EROSION CONTROL AND GRADING PLAN

SUPERSTAR CARWASH

MEADOWBROOK PKWY

SC-1 Silt Fence (SF)

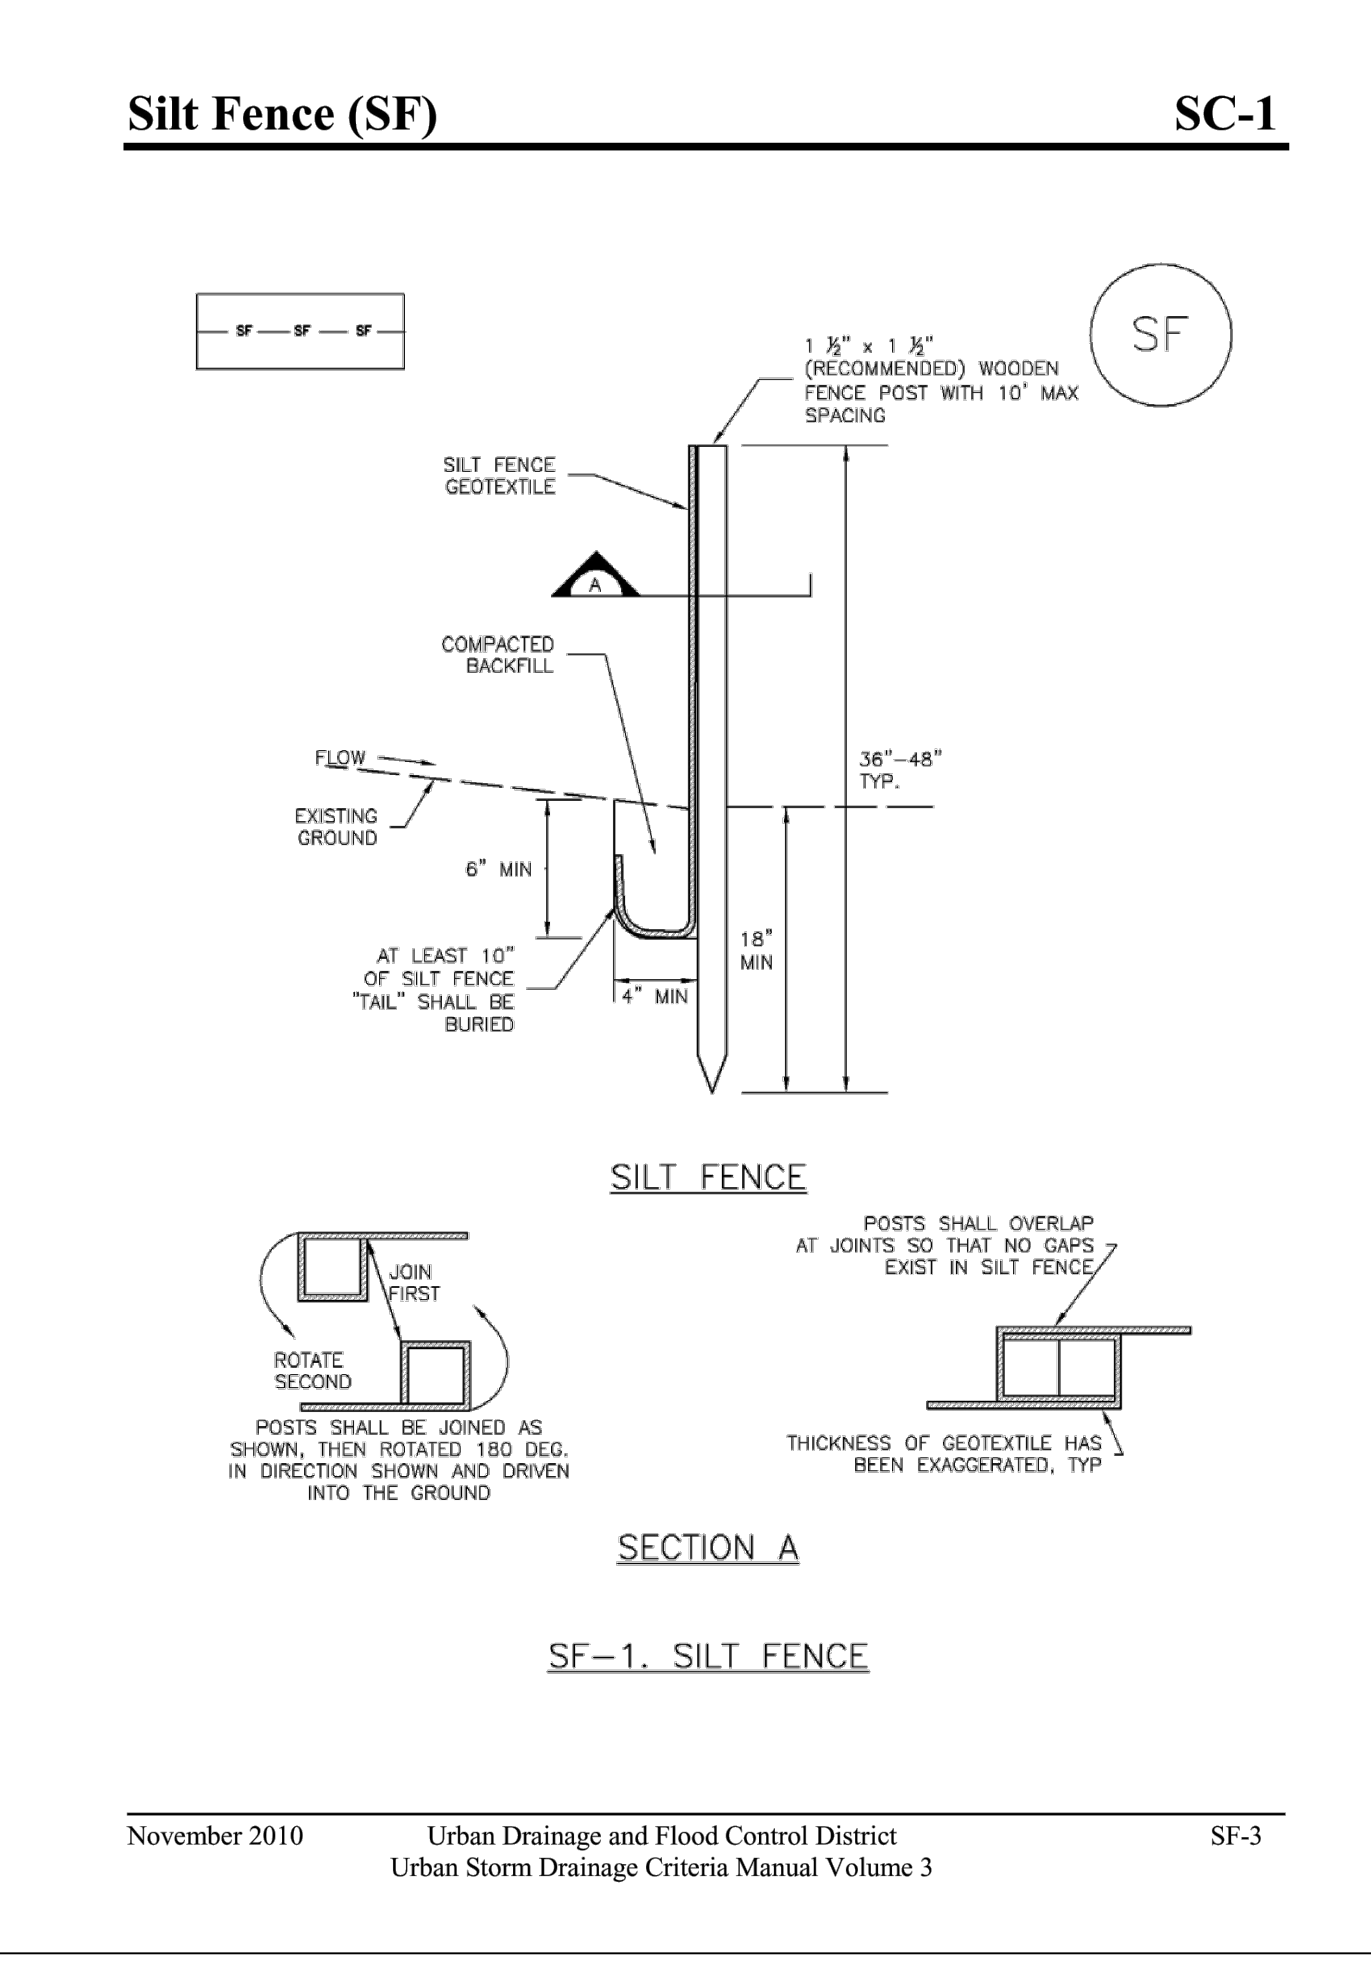
GEC Checklist item z:
-Add CWA detail.
-Add temporary sediment basin details.
-Add details for seeding and mulching.
-Add temporary soil stockpile BMP detail

this is for curb inlets. Provide detail for grate inlets
